From: Nissa Talbot (LFR) <Nissa.Talbot@lincolnshire.gov.uk>
Sent: 18 March 2025 15:38
To: _planningadvice
Cc: Hill, Jess
Subject: RE: H13-0058-25: Decoy Farm, Moulton Chapel

H13-0058-25
Decoy Farm Fen Gate, Fen Gate, Moulton Chapel, PE12 0XL
Conversion of existing stable block 2 self contained units to provide assisted living accommodation

Decoy Farm Moulton Chapel

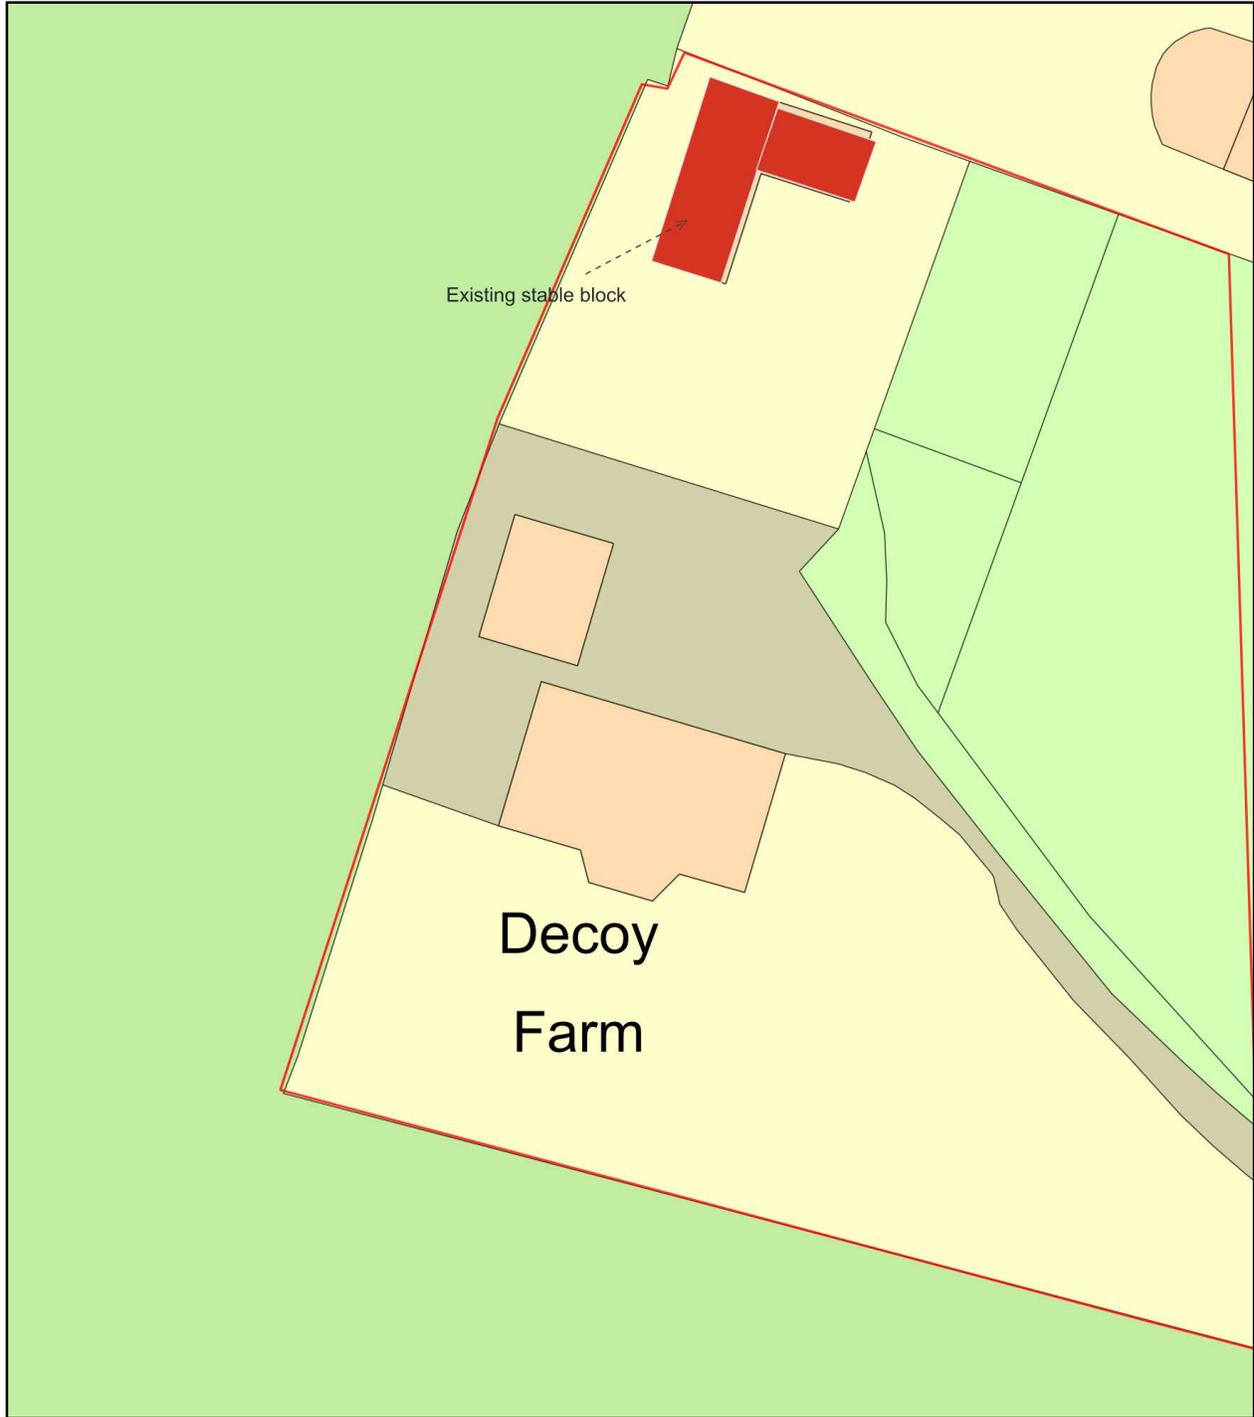
It is noted that we have not given specific details of the objection related to B5 access, however, this is not for Lincolnshire Fire and Rescue to prescribe. The intention behind this was to allow the applicant to review the requirements and provide evidence that the access provisions will be compliant with ADB. However, to offer some guidance, particular attention should be given to road width, as specified in Table 15.2 of ADB B5. The road width needs to be 3.7m wide, looking at the plans provided the smallest part of the road leading to the proposed sleeping accommodation does not meet this requirement. The added sleeping risk of the proposals change of use exacerbates this non-compliance with ADB.
